Planning Application S6/2010/0134/FP

I understand the above application relates to the removal of the existing brick and flint wall and replacing it with metal railings.

WOODFIELD LANE ELEVATION
PROPOSED NEW RAILINGS
1:75

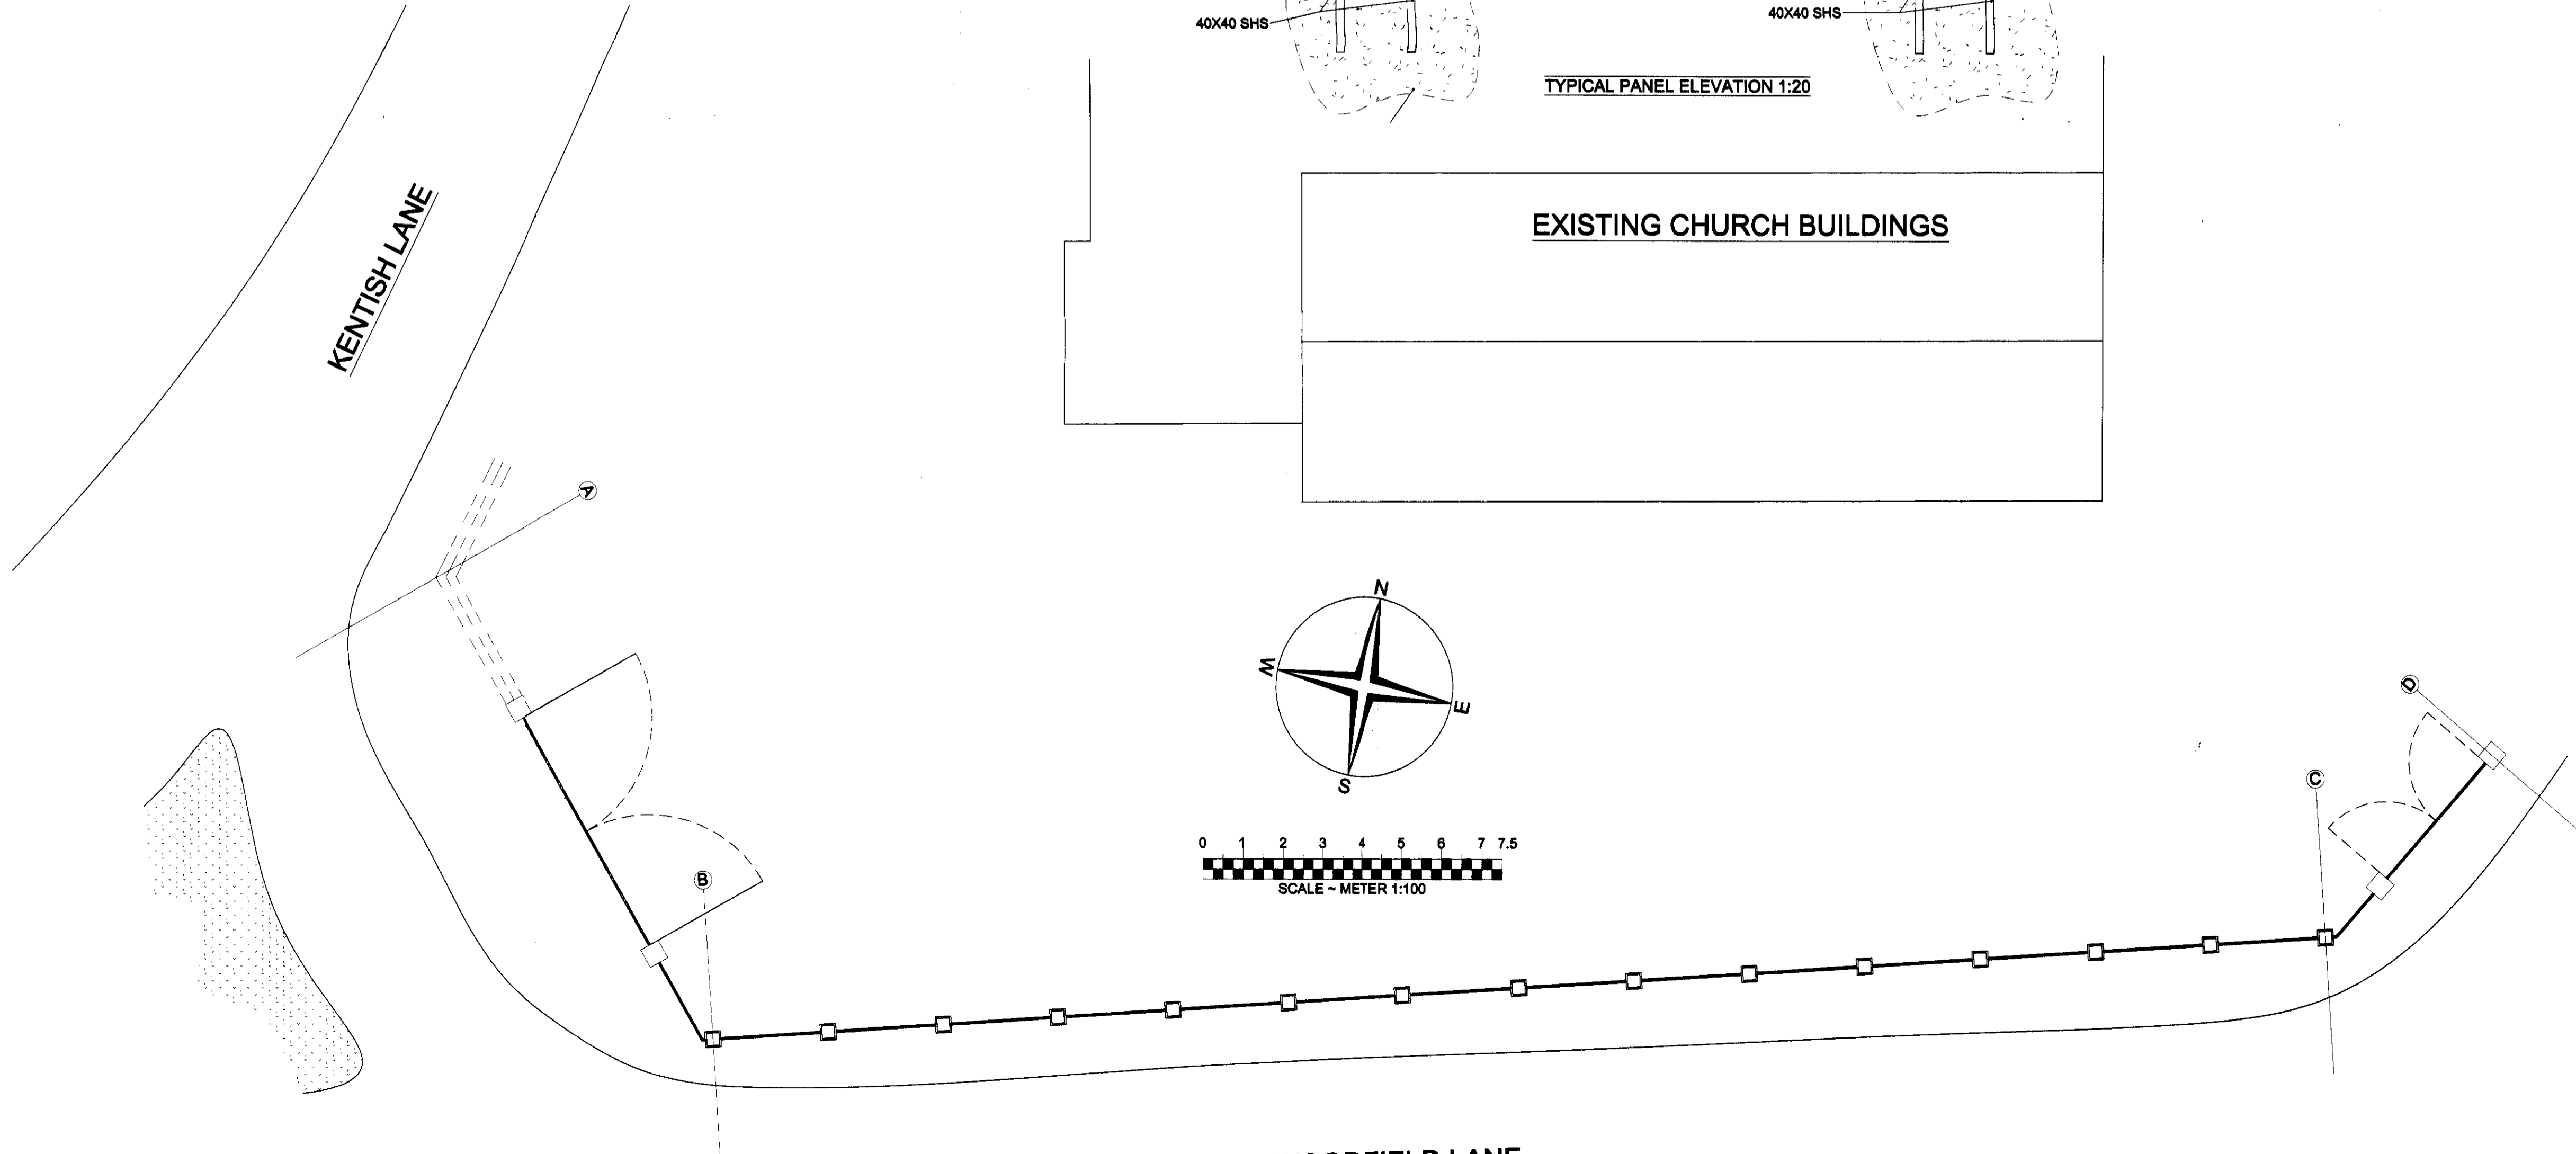
As an immediate neighbour I am surprised I have not been notified, but I am opposed to the removal of the historic wall that matches the church building - the proposed railings are quite inappropriate for a rural setting such as this is and would be better to repair the existing wall.

Has the Conservation Officer been consulted on the proposal?
